Re: ABP case reference : 324258

Applicant : Constant Energy Limited_Tirawley wind farm

In ABP case reference **324258** to which this observation refers, the applicant has, as one can see in Map 1, next page, ignored the turbine separation distances from adjacent turbines, that are recommended in the WEDG2006 guidelines.

- NOTES
1. FIGURED DIMENSIONS ONLY TO BE TAKEN FROM THIS DRAWING.
  2. DRAWING TO BE USED FOR **PLANNING PURPOSES ONLY**.
  3. ALL LEVELS REFER TO ORDNANCE DATUM (MALIN HEAD).
  4. ENGINEER TO BE INFORMED OF ANY DISCREPANCIES BEFORE ANY WORK COMMENCES.

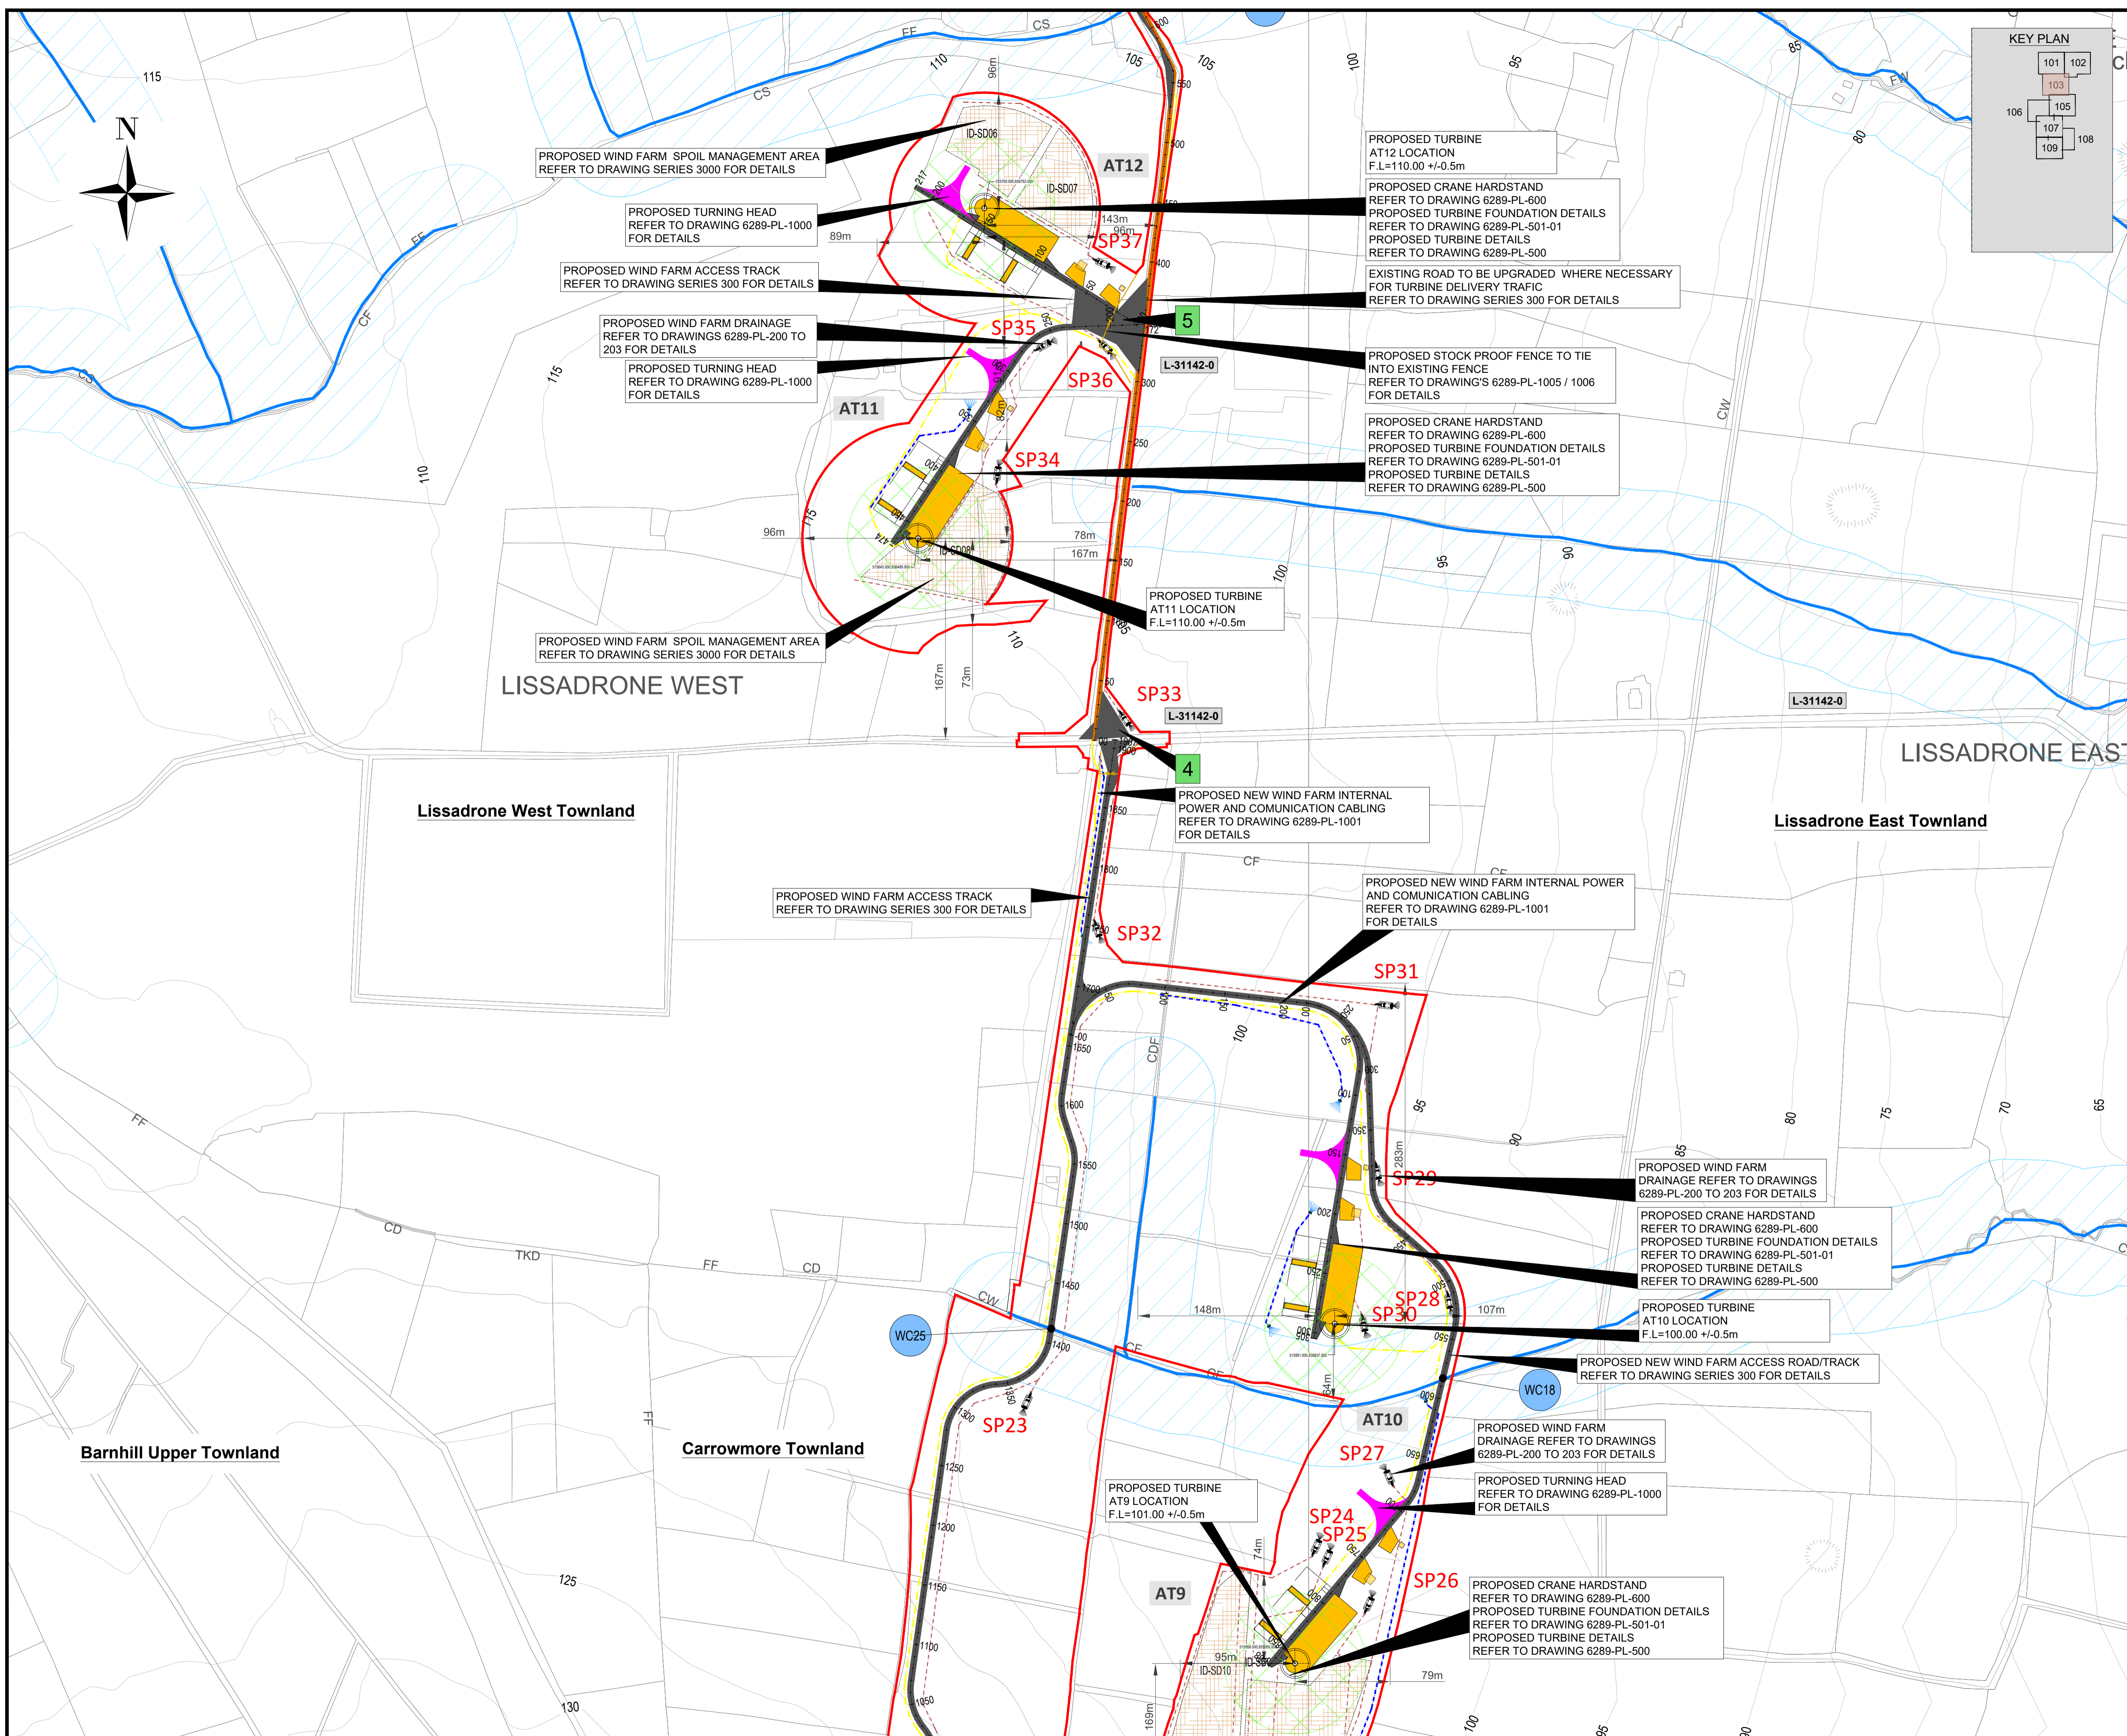
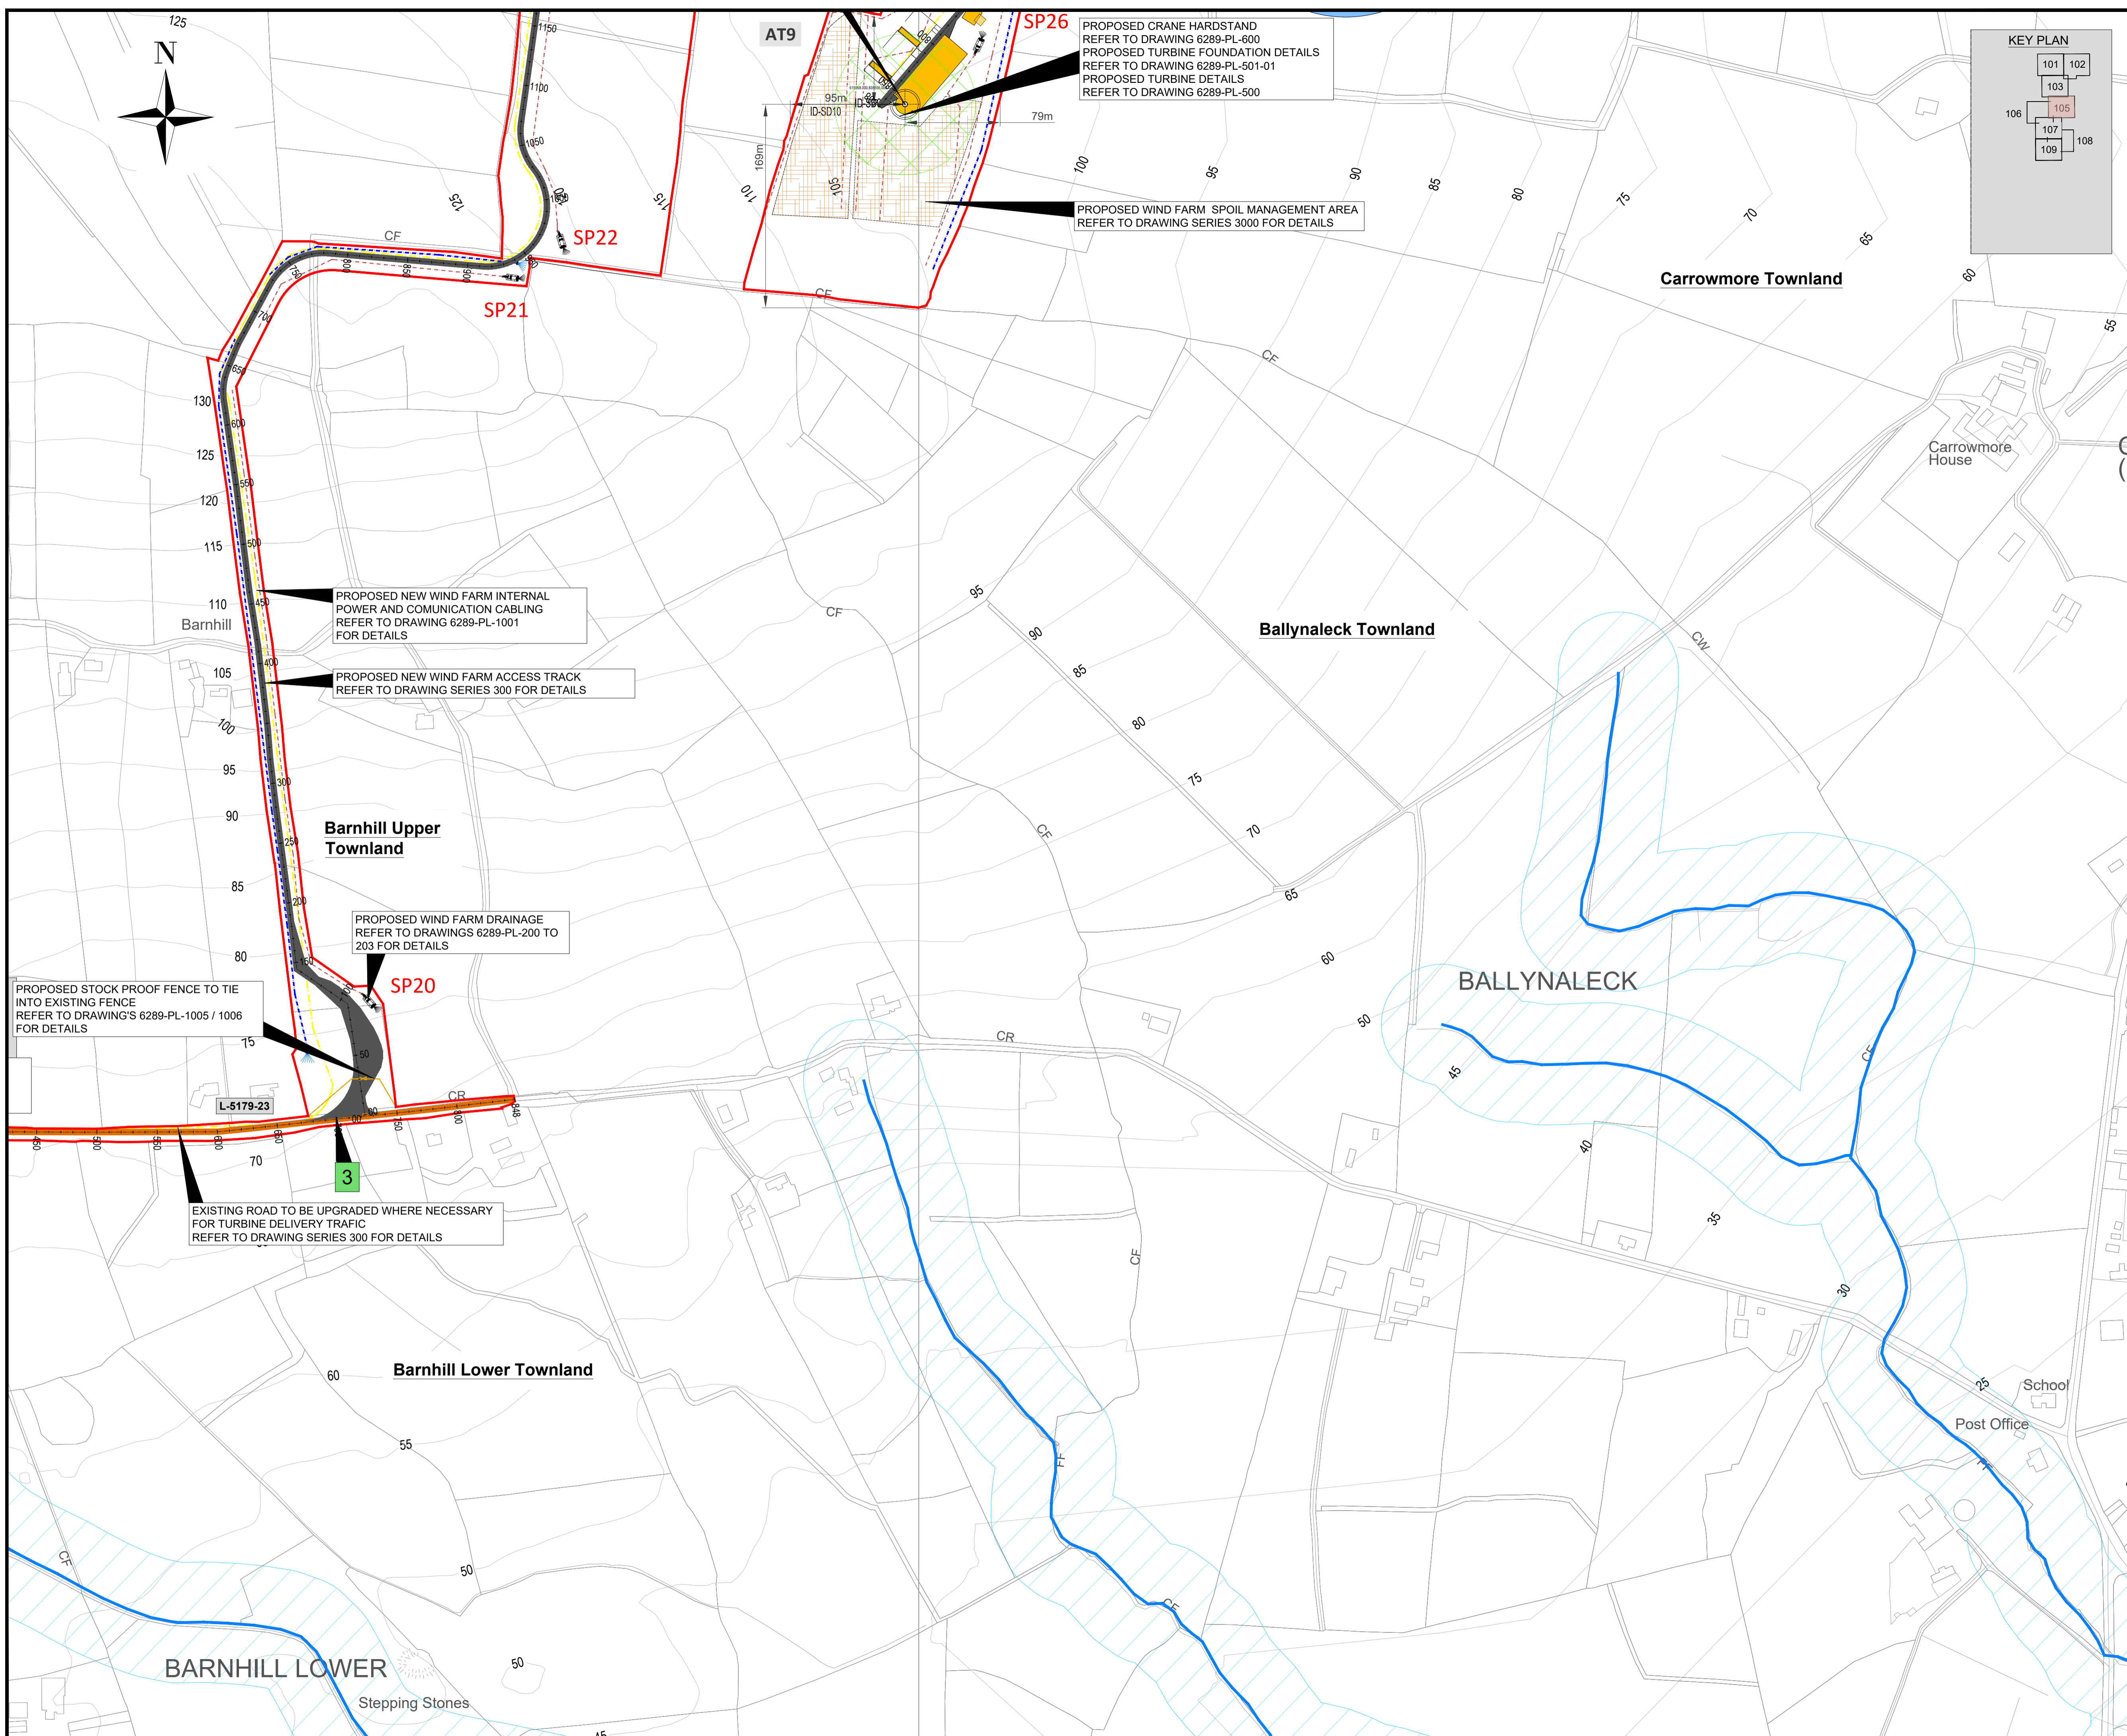
AT3 to AT4 has only 2.86 rotor diameters instead of 7 rotor diameters. 41% of required separation
AT6 to AT5 has only 2.34 rotor diameters instead of 7 rotor diameters. 33% of required separation
AT7 to AT8 has only 2.43 rotor diameters instead of 7 rotor diameters. 35% of required separation
AT9 to AT10 has only 2.38 rotor diameters instead of 7 rotor diameters. 34% of required separation
AT11 to AT13 has only 2.87 rotor diameters instead of 7 rotor diameters. 41% of required separation
AT13 to AT14 has only 3.13 rotor diameters instead of 7 rotor diameters. 45% of required separation
AT11 to AT14 has only 4.30 rotor diameters instead of 7 rotor diameters. 61 % of required separation

I would also include AT2 to AT3, AT10 to AT11, AT15 to AT16 & AT12 to AT13 in those 7 rotor diameter separation requirement as they have not a much lesser prevailing winds from the South Southeast and the West northwest directions.

On the basis of what I have outlined and experienced, I highly recommend the aforementioned issues be carefully considered, and the design be altered significantly.
